**Application by Vattenfall Wind Power Ltd for the Thanet Extension Offshore Wind Farm Development Consent Order**  
**The Examining Authority's third written questions and requests for information (ExQ3)**  
**Issued on 16 May 2019**

Historic Environment
Features (Onshore) -
Sheet 2 of 3

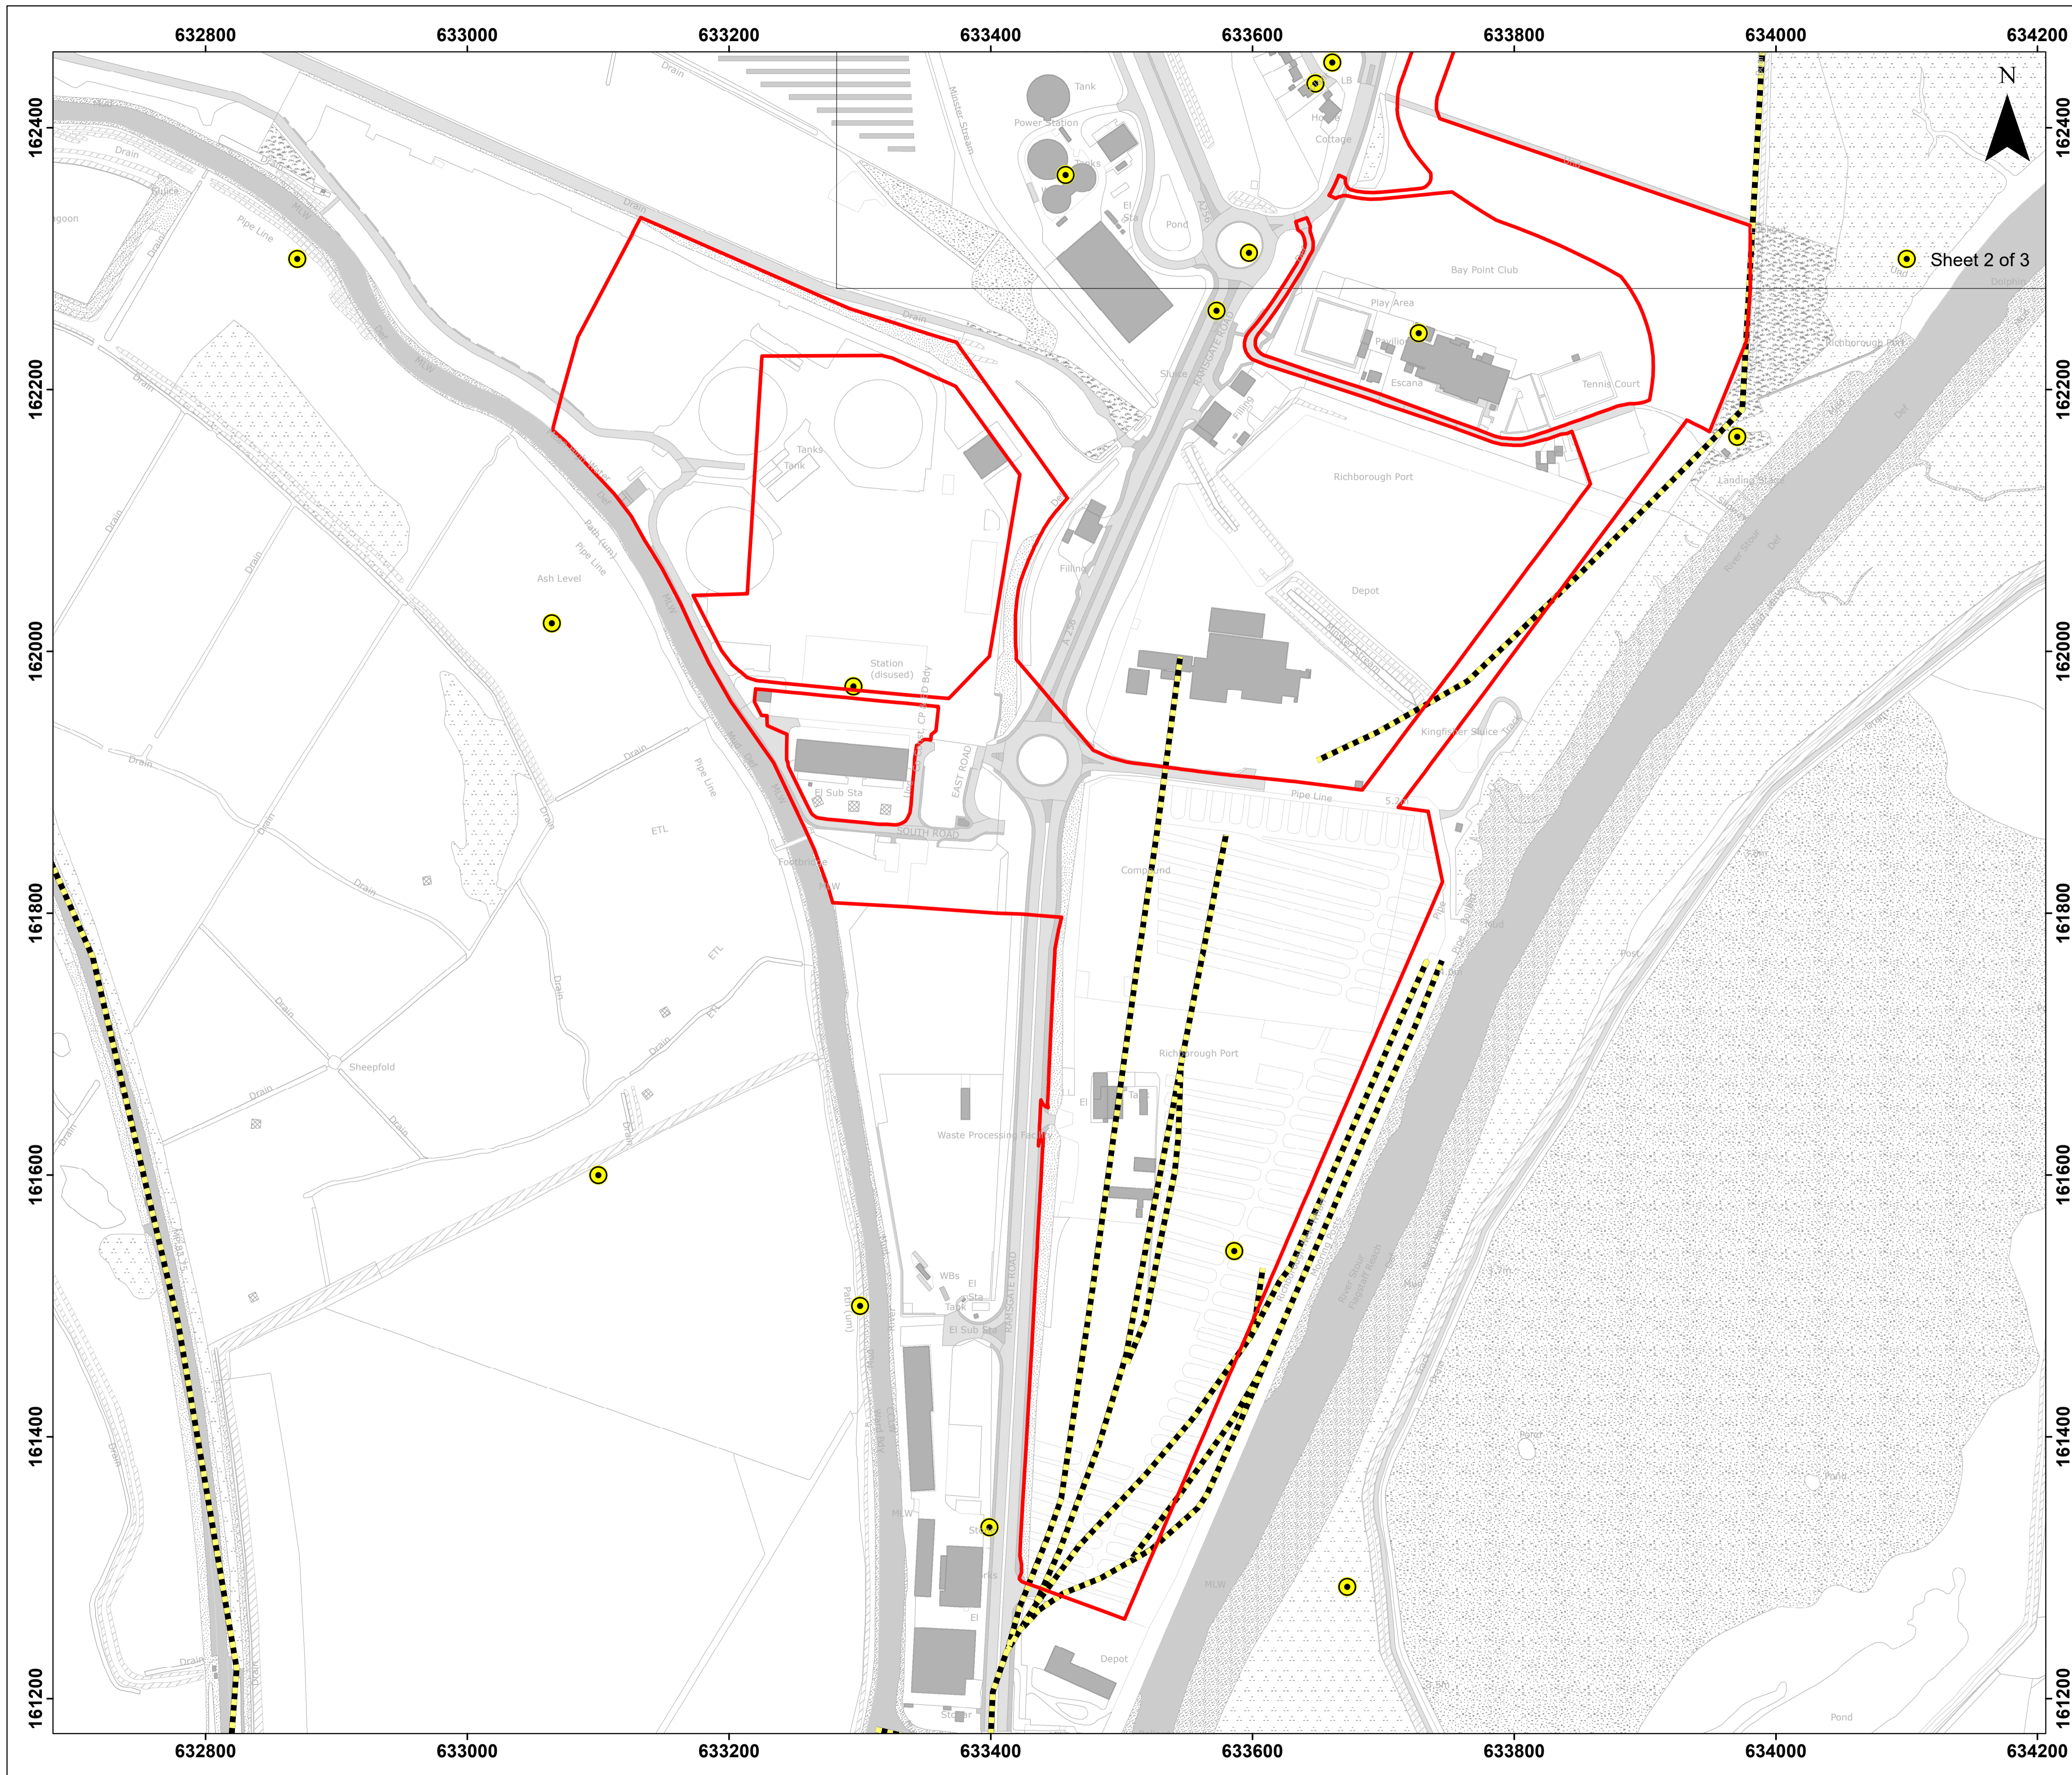
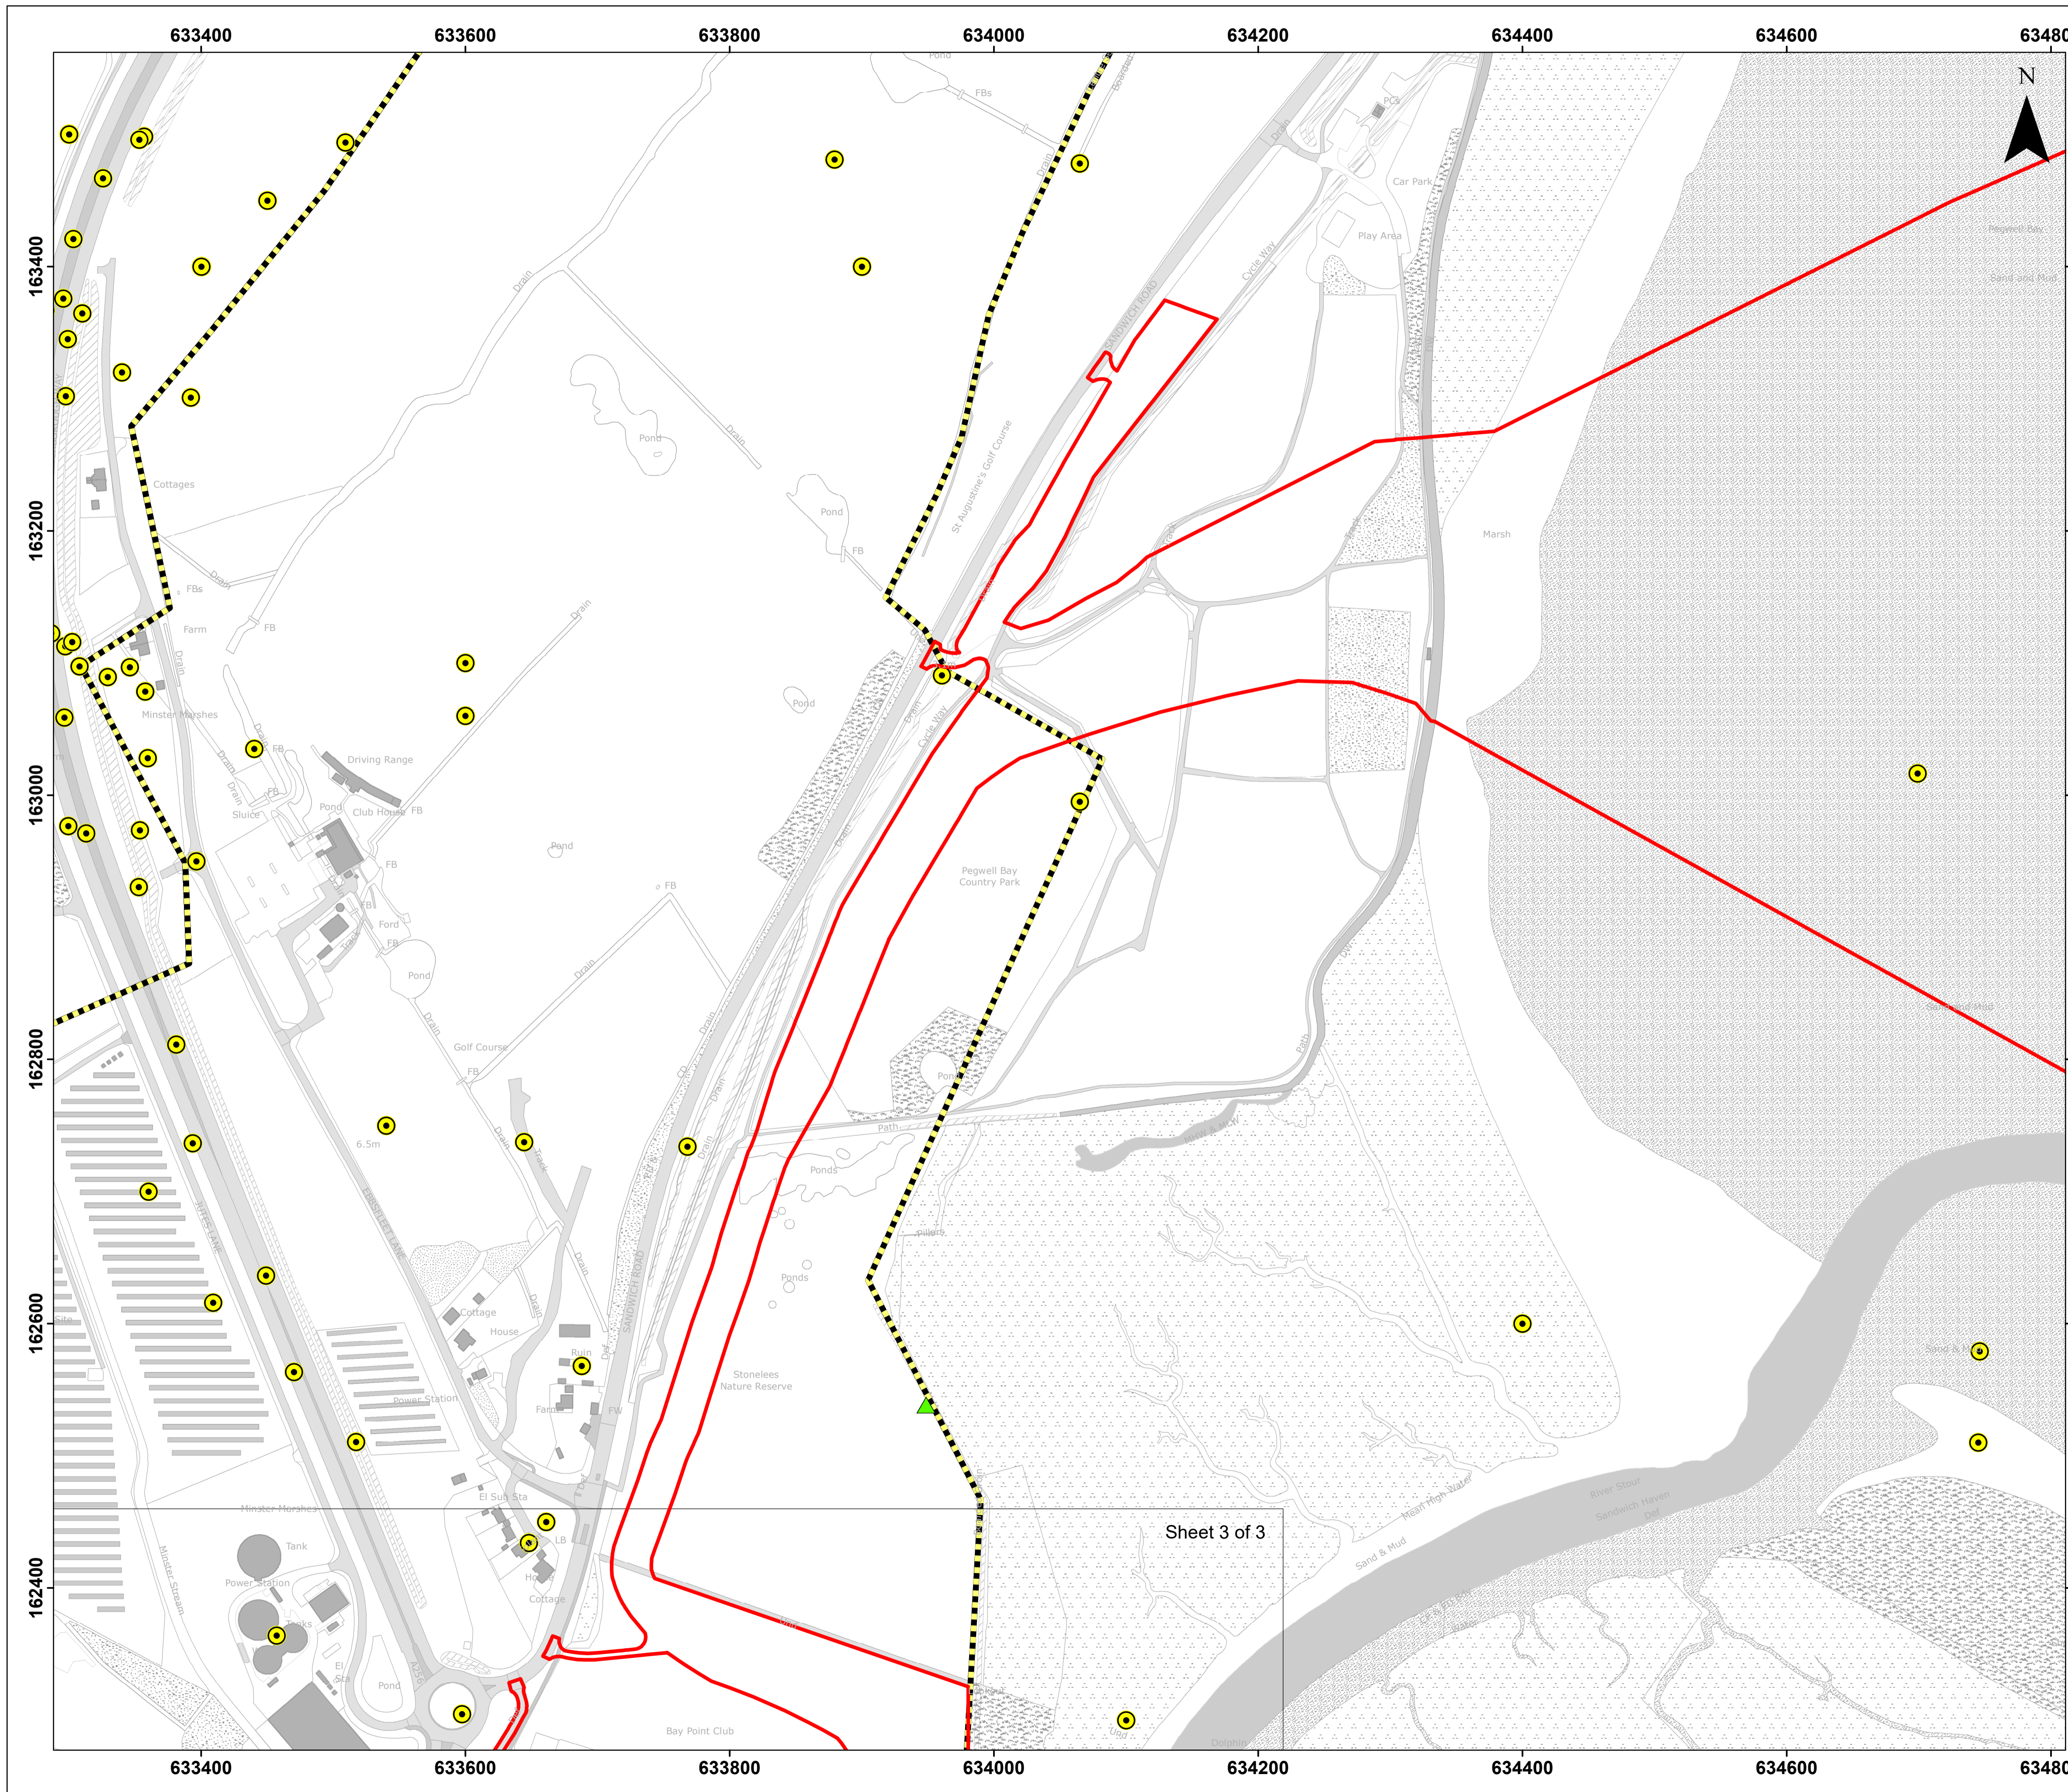
3.10.4.	The Applicant	<p><b>Draft Onshore WSI: Previously undisturbed land parcels</b>            The Draft Onshore WSI [REP5-006] submitted at D5 para 4.4.11 refers to previously undisturbed areas and now draws attention to the parcels of land within the red line boundary considered to be previously undisturbed or at least less disturbed areas. It refers to Parcels 3, 4, 5, 8, 13 and 14.</p>

ExQ3	Question to:	Question:
		<p>Would the Applicant please check and clarify these references to undisturbed areas, because from [APP-063] Figure 7.1 "Heritage Assets Potentially Subject to Direct Effects": 3 is the grid connection site, 4 the Ramac land, 5 is outside the red line boundary, 8 is partially in Stonelees, 13 is the golf course and appears to be outside the red line boundary and 14 is Pegwell Bay Country Park. Whether these are indeed the areas of land intended to be described as undisturbed, or alternatively the text is meant to refer to Works Areas or other areas, greater definition and precision is needed and should be indicated on an updated version of the Heritage Assets set of plans.</p>
